Subject: 21/02180/REM - OS Parcel 9507 South Of 26 And Adjoining, Fewcott Road, Fritwell

I am concerned that when comparing the Lockhart and Garratt Arboricultural impact Plan with the Detailed landscape Design Overview the landscape proposals do not accurately indicate the positions of hedgerows 23 and 20, nor the positions of the retained trees around the perimeter of the site. The arboricultural plan should be used as the constraints/base layer to the landscape proposals.

Figure 2 Proposed habitats

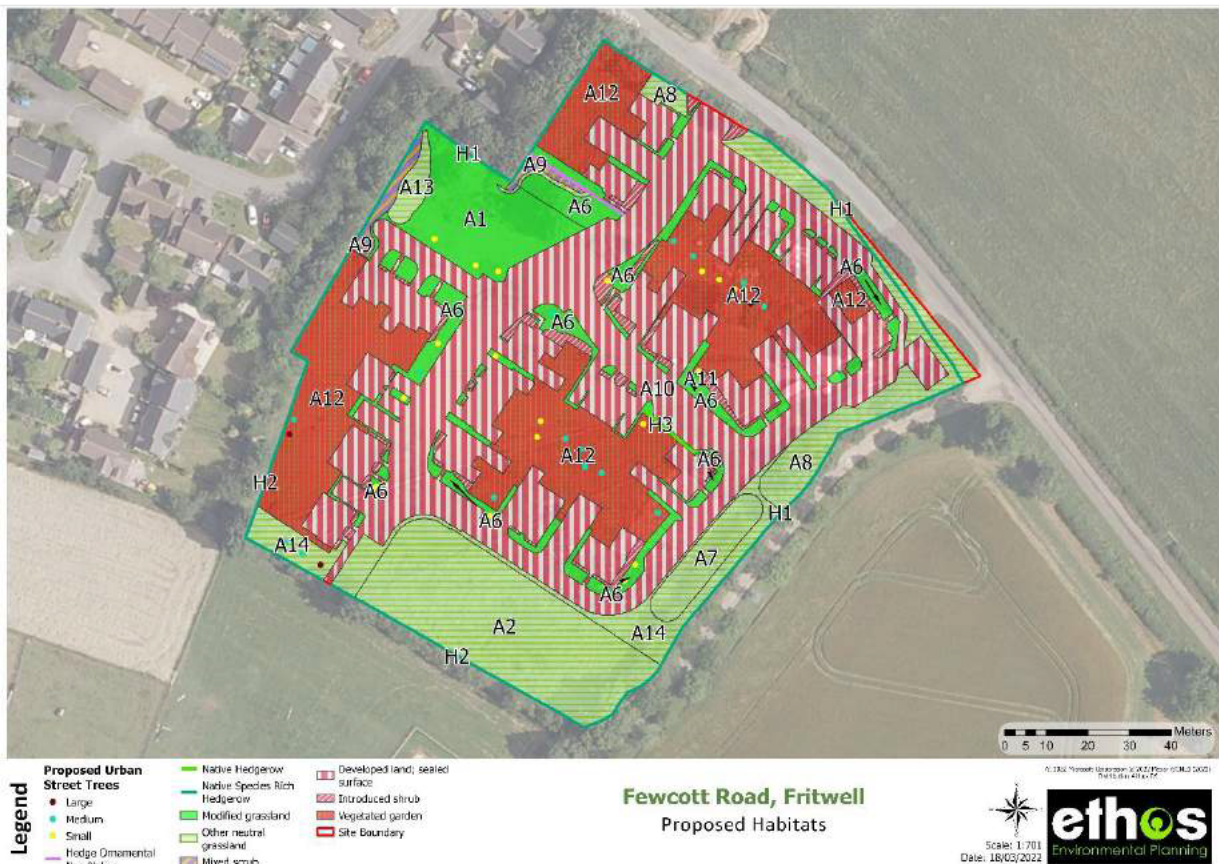
The southwest-facing brick boundary wall to the garden will be hidden by native scrub proposed. I have concerns about this, both in terms of structural integrity of the wall once the scrub has established, taking out moisture from the soil, causing it to shrink, and the overshadowing of the garden from the mature height of the scrub shrubs. Access to inspect and maintain the wall is also important for the resident. I would prefer to see low-ground cover (*Vinca major*) interplanting with 5 irregularly placed *Corylus avellana* (Hazel) in place of the native scrub. This wall could become the feature (stone) wall for the general amenity of the open space.

The native scrub planting appears to be appropriate on the western boundary of the open space. This will entail much clearance of already developing natural scrub. The proposed tree species and locations are acceptable.

I suggest for visual interest and distinctiveness a circle of trees of similar species are included with the open space – refer to enclosed plan.
